Consultation Response from KC, Lead Local Flood Authority
2023/93667 Storthes Hall Student Village, Storthes Hall Lane, Kirkburton, Huddersfield, HD8 0WA
Outline application for demolition of buildings and erection of residential development (up to 261 dwellings), redevelopment of Lodge Cottage for residential use and associated works
Date Responded: 24 th July 2024 Responding Officer: Paul Farndale Responding Ref:

Kirklees Flood Management & Drainage acting as Lead Local Flood Authority continue to OBJECT to this application on the grounds of flood risk.

INDICATIVE MASTERPLAN
1826-MP-01
STORTHES HALL, KIRKBURTON
UBRIQUE
SCALE:1:1000@A1 - NOVEMBER 2024

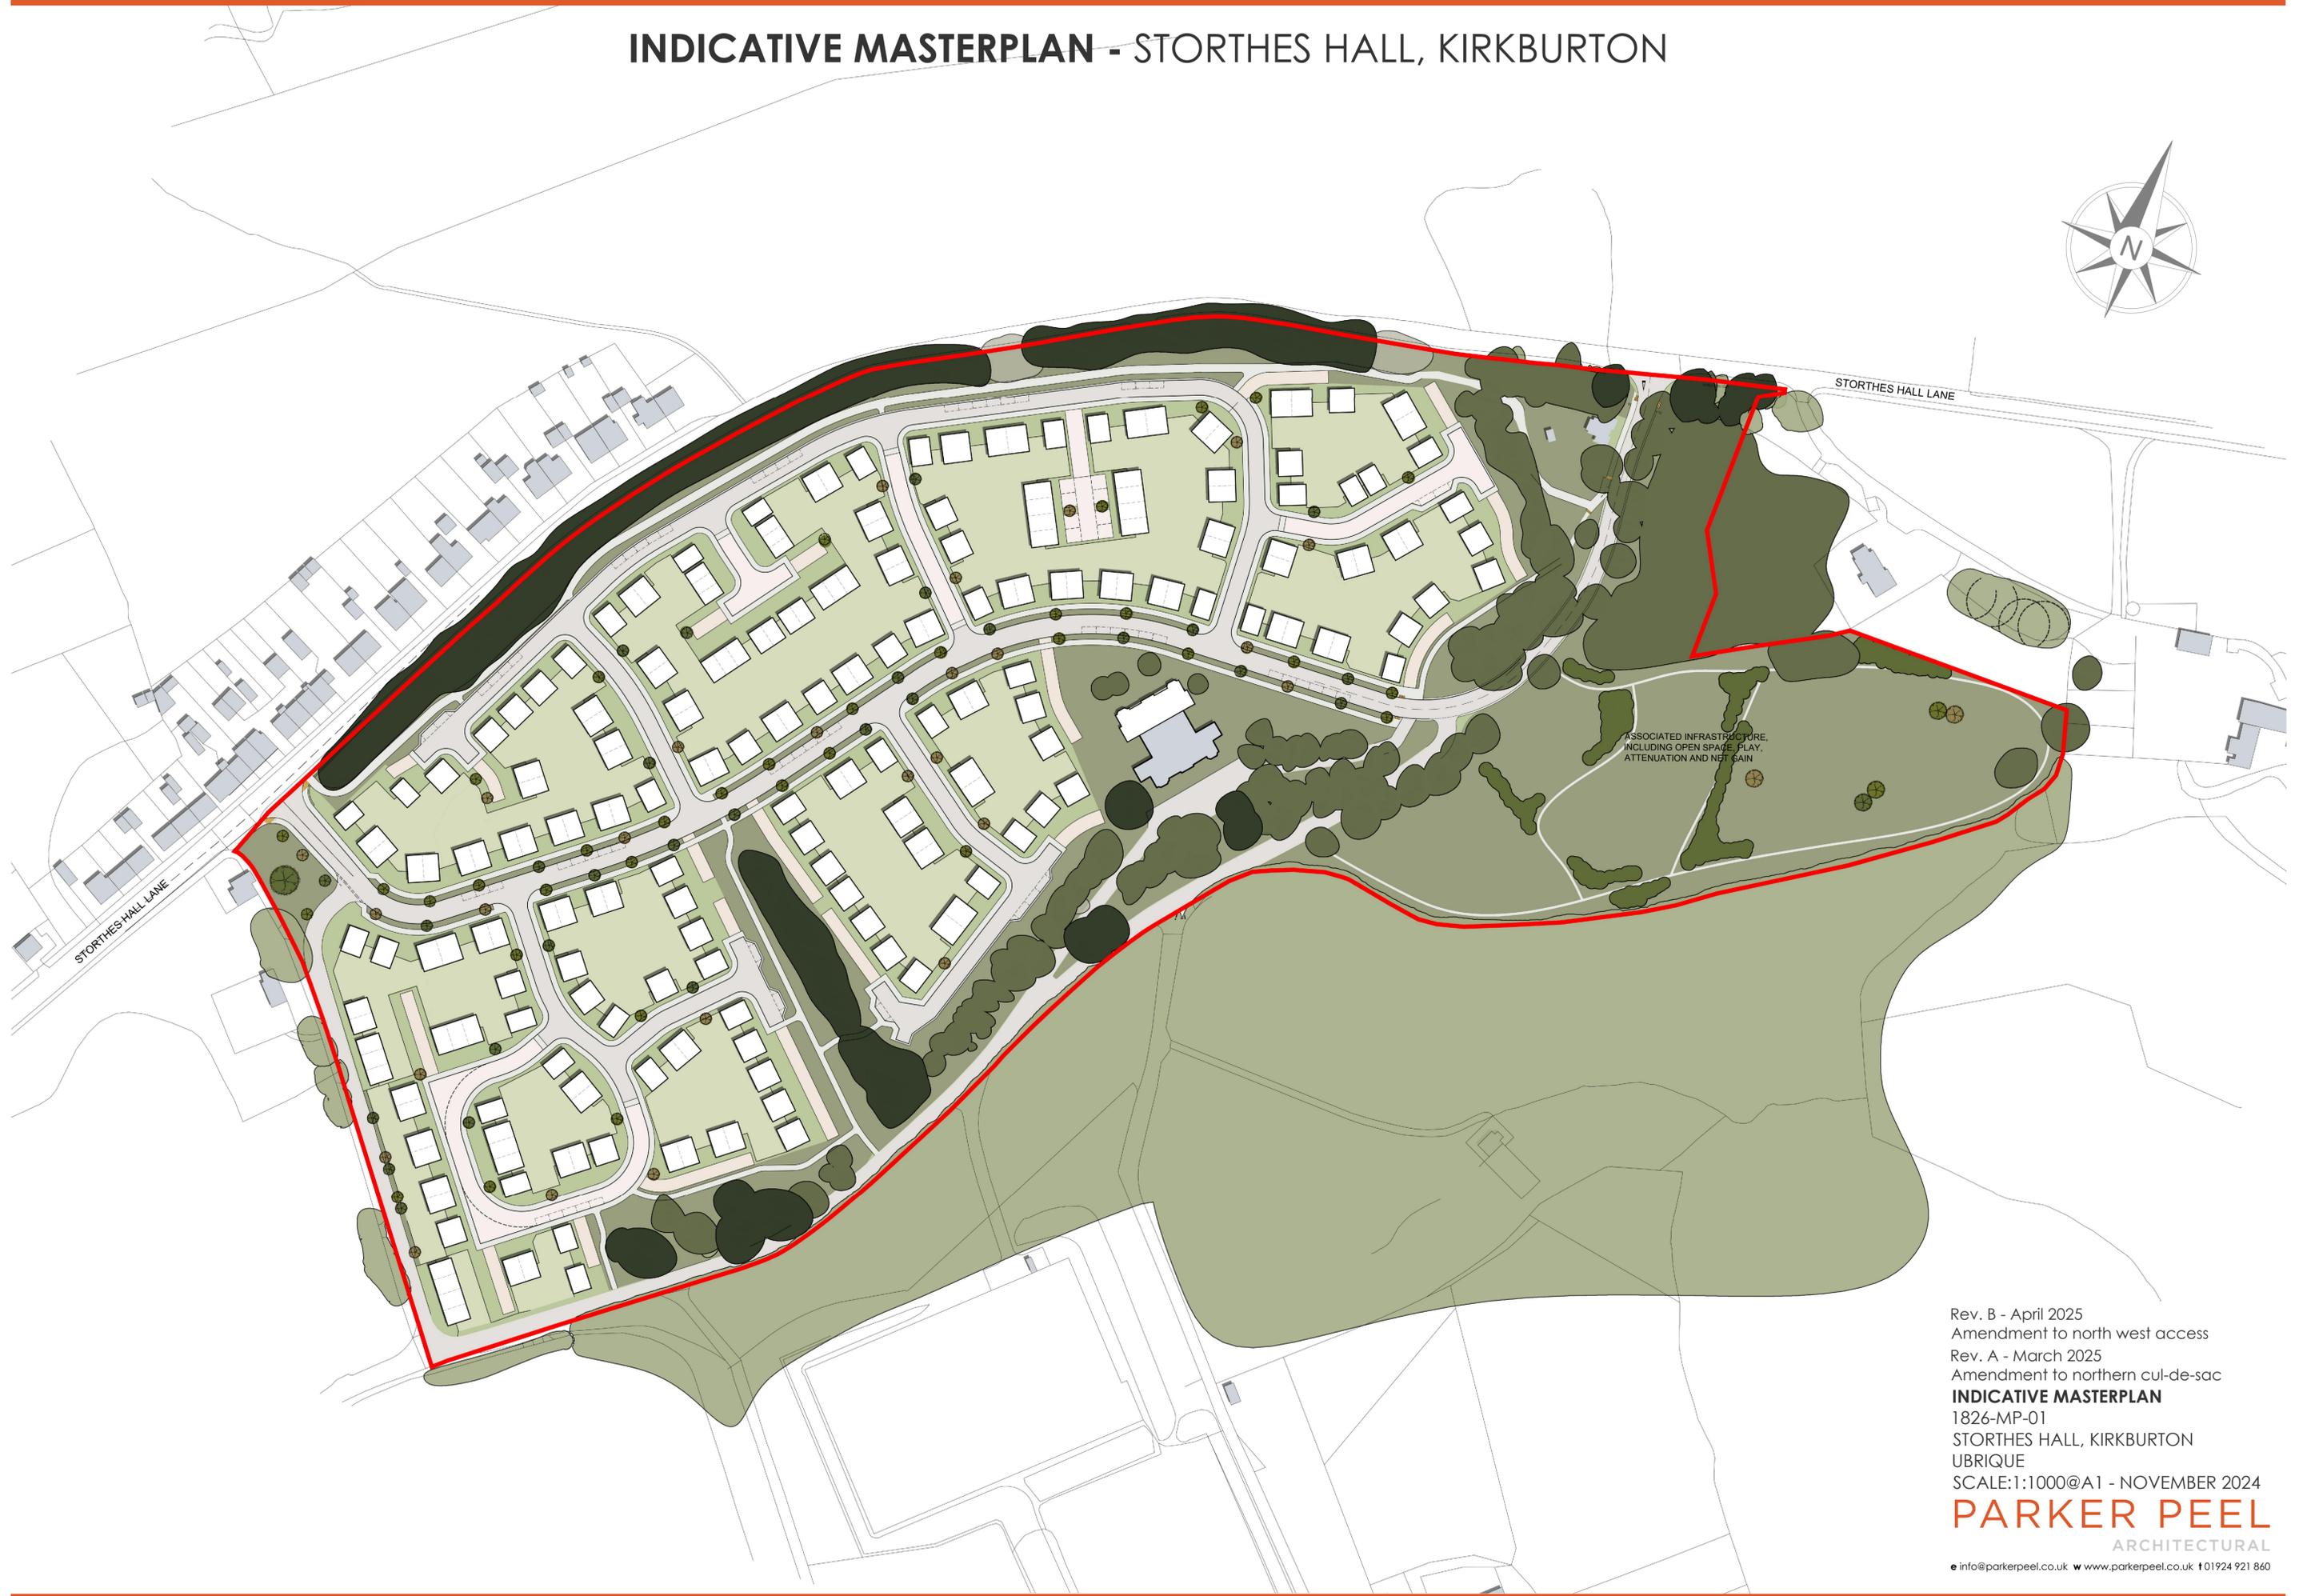
A submission on flood routing attempts to address concerns around localised low spot and provides more information as requested for plots 40/41, 17/18, 212, and 71.

However, flood routing relies on going through curtilage or provides little and inadequate freeboard for ponding in the road. This shows that the layout was not designed with flood routing in mind and 'making space for water'. Instead, an attempt to create a flood route using the layout is presented and creates risk as a result. Small cul-de-sacs are omitted from this assessment if they are separated in terms of direction of flow from other estate roads.

We therefore feel that this unacceptable compromise and the design layout should be based around safe routes to provide the best solution, not the converse. This is consistent with Kirklees's approach to all major sites. Curtilage should be avoided, and road network and open space positioned and utilised for flood routing.
